**RE: Stack Short Plat
SP-22006 – Third Submittal**

Please refer to our responses below which address all review comments received from the City of Marysville on January 18th, 2023, regarding the Stack Short Plat submittal package. You will find the markup comments listed in the order that they were written followed by our response in *italics*.

STACK DESIGN & CONSTRUCTION, LLC
STACK SHORT PLAT
 PRELIMINARY SITE PLAN

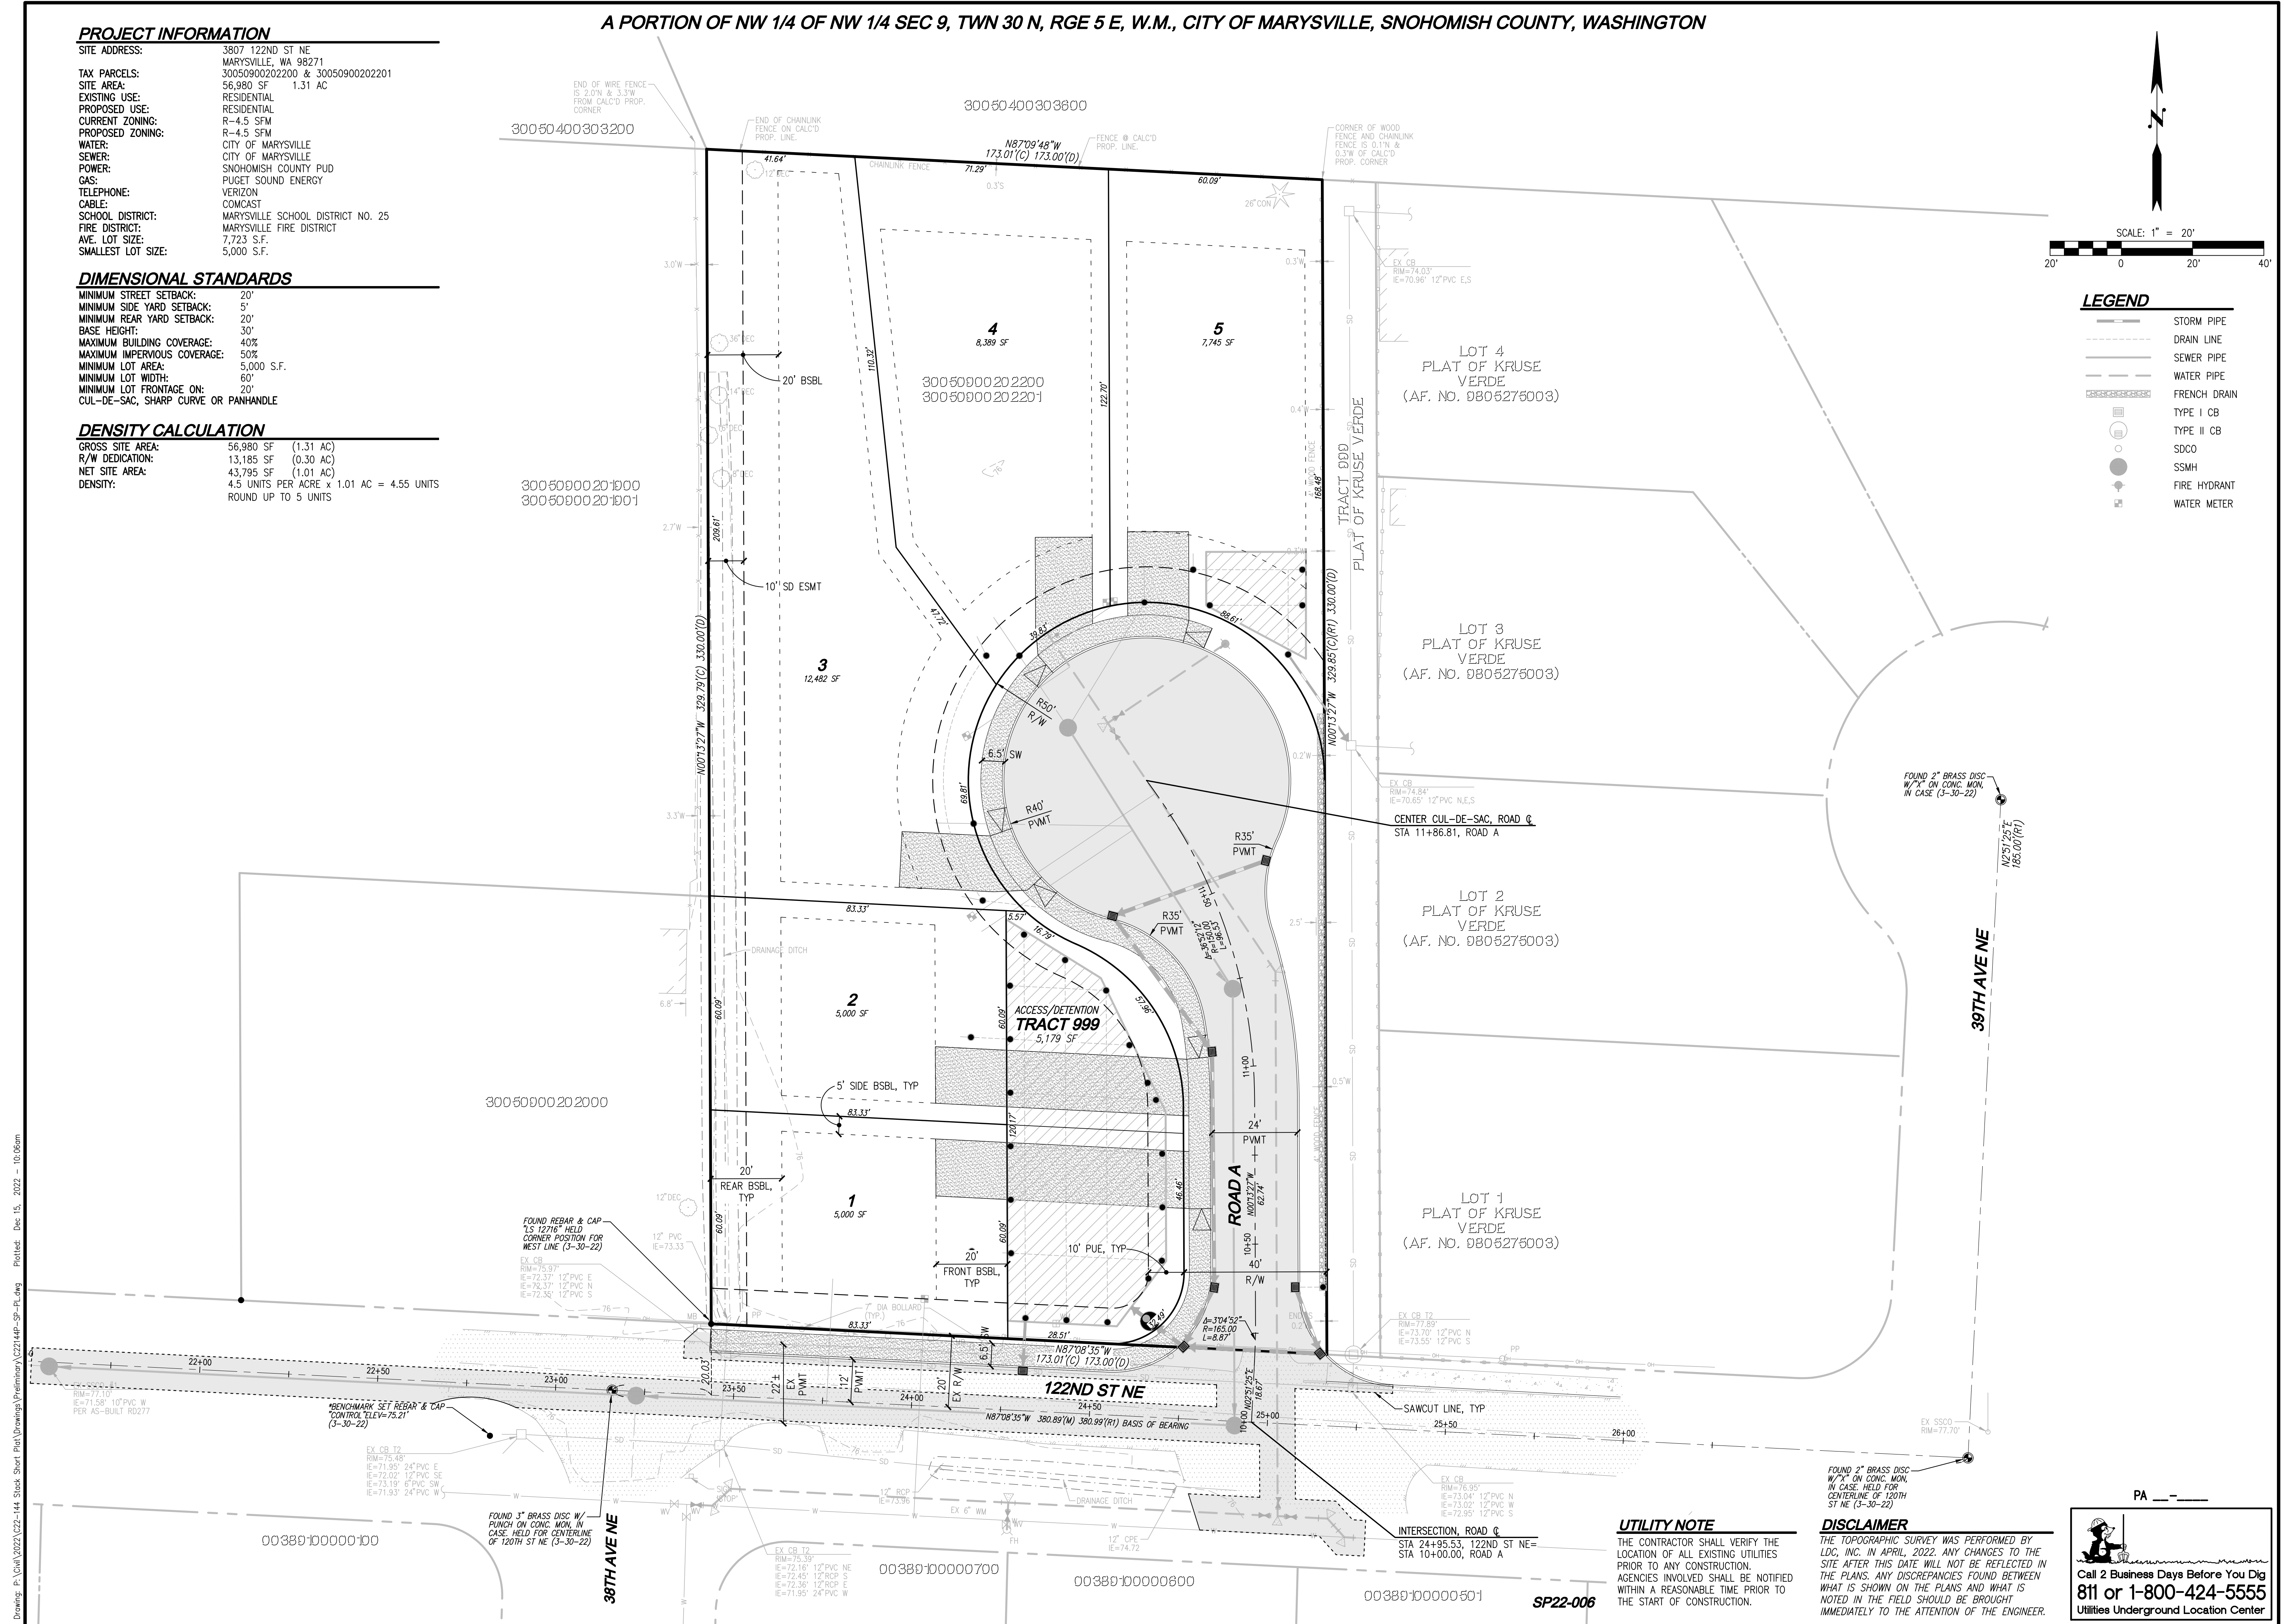
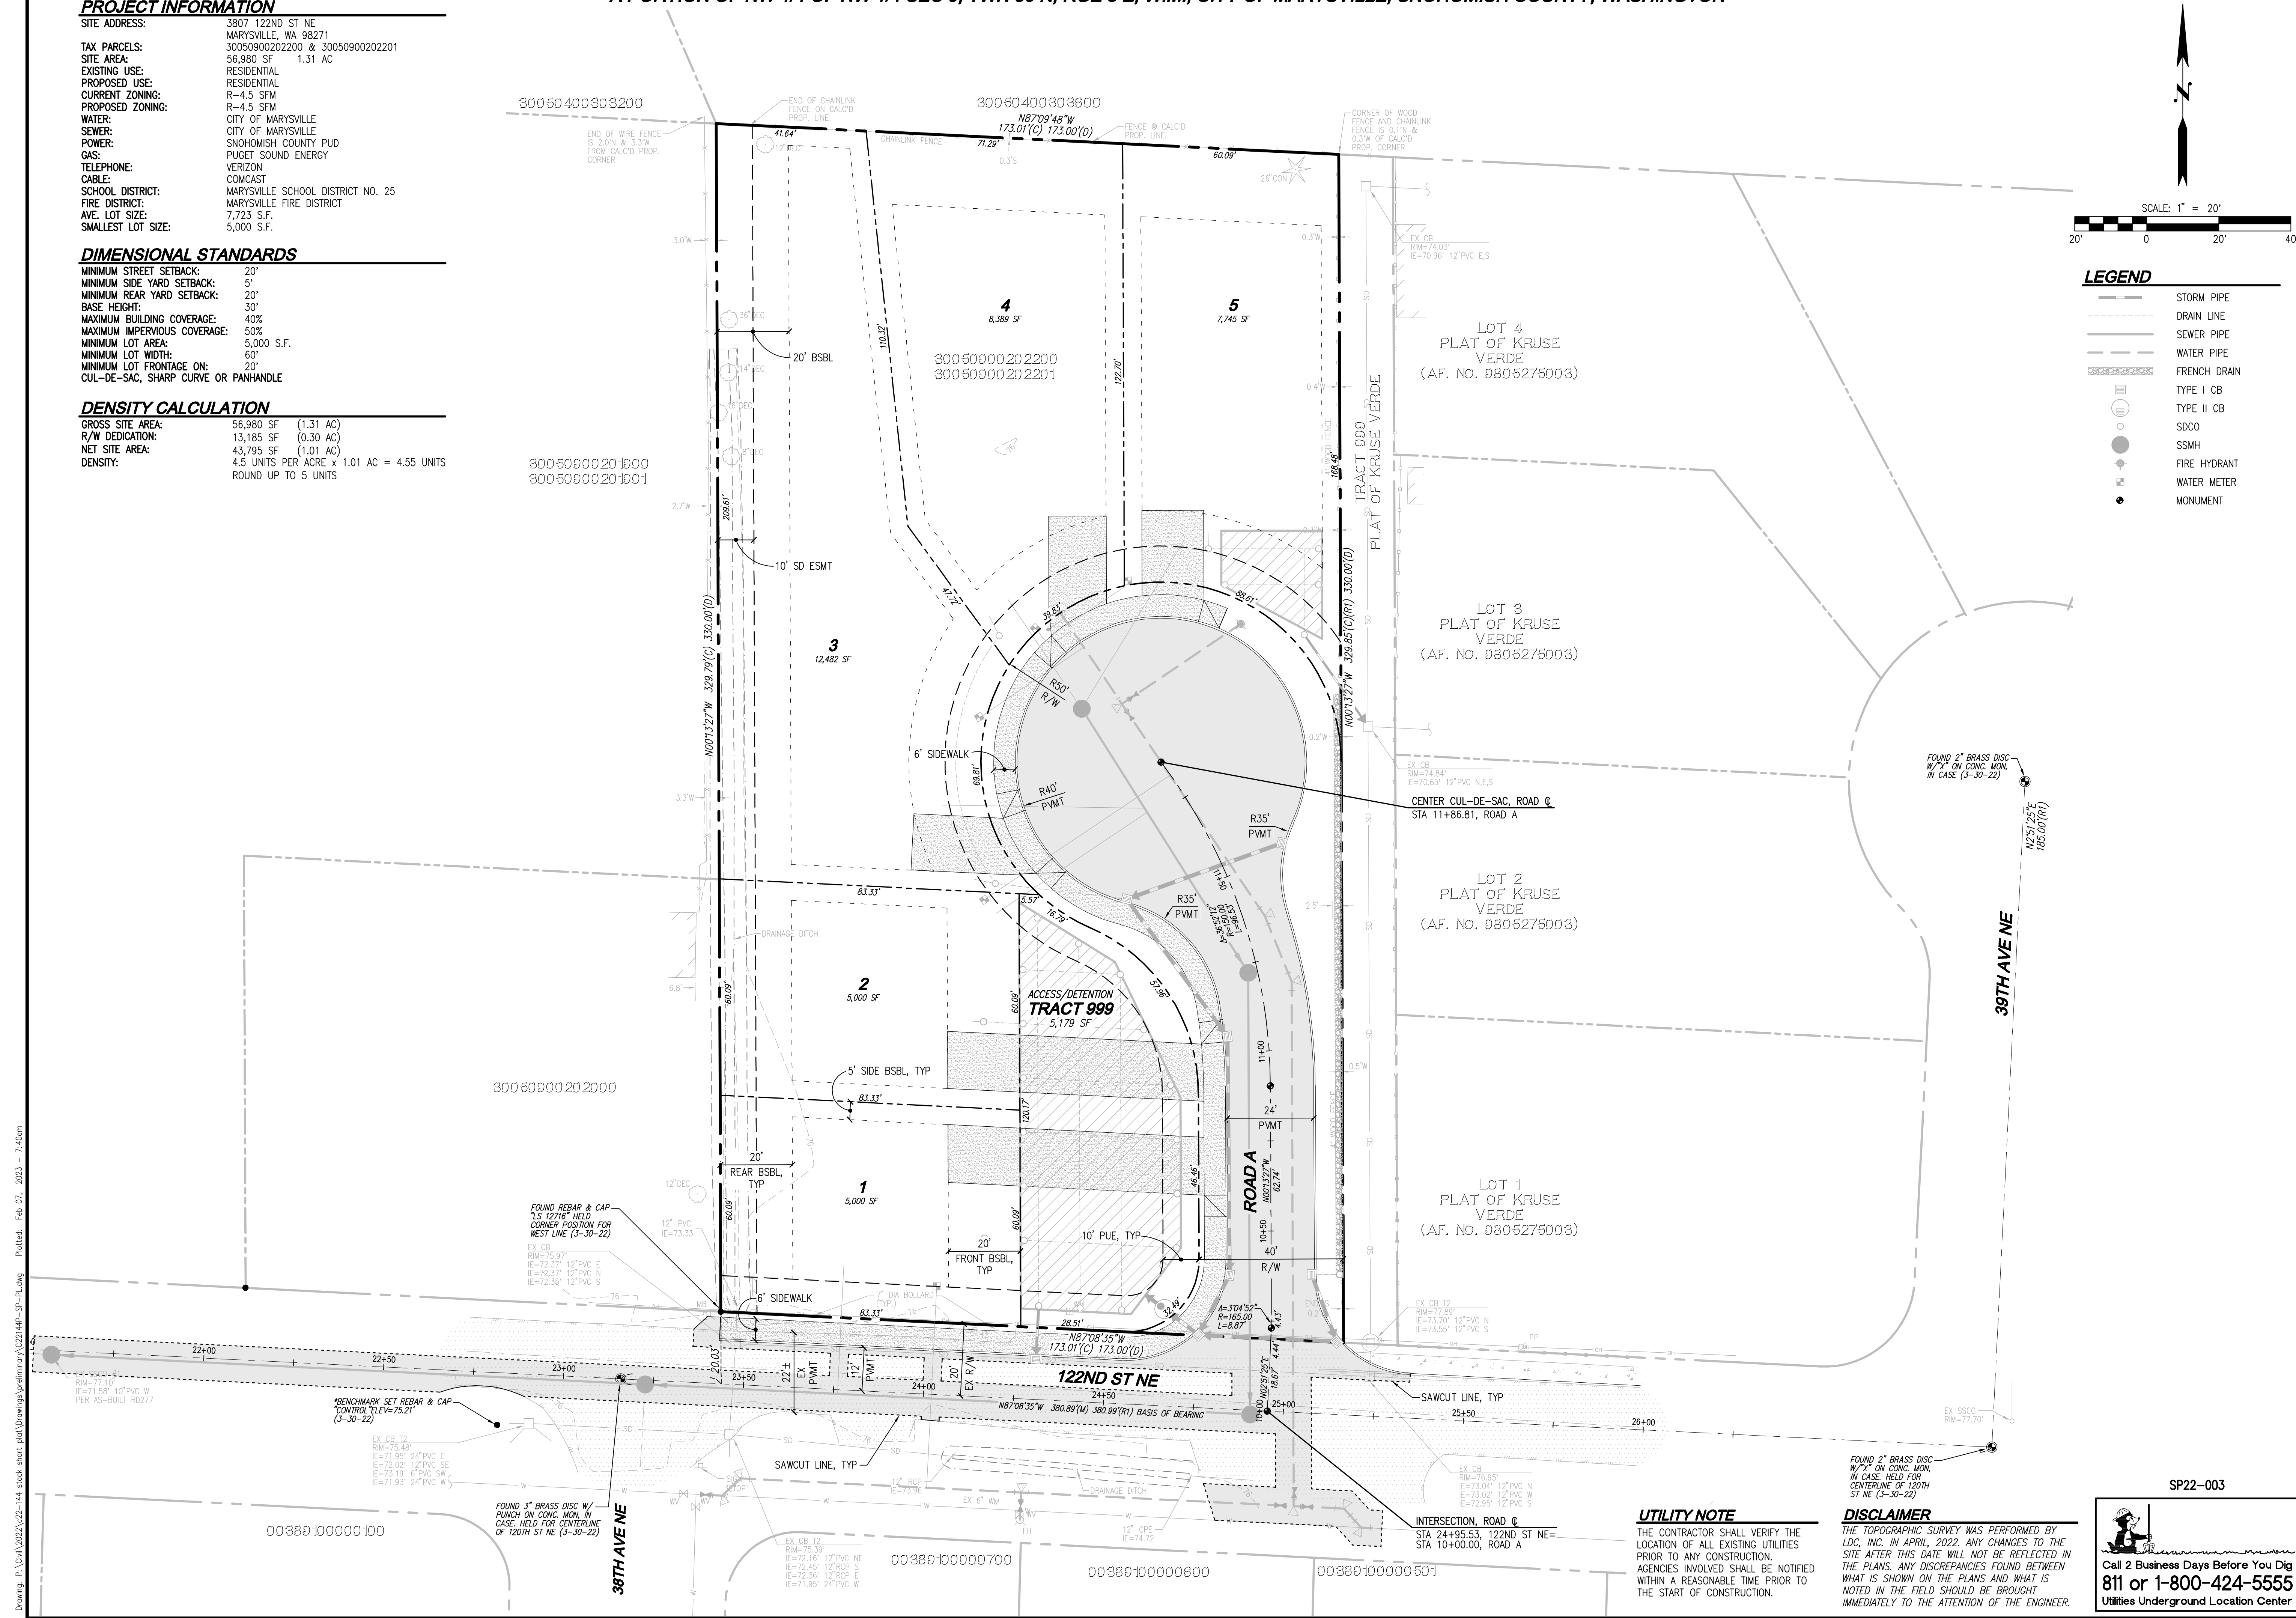
1. TRC2 Comment: The entirety of Tract 999 will be required to be relocated west behind Lots 1 & 2 adjacent to APN 30050900202000, not the overflow path exclusively. Tract 999 shall not include private driveway access. Maintenance access to Tract 999 will be allowed to be accessed off of 122nd Street NE.

- a. Public Works Traffic Division does not object to Variance request if sidewalk is fully extended along full frontage of all residential lots including Lot 5.

Response: After coordination with the City complying with this comment is not required.

Response: Noted
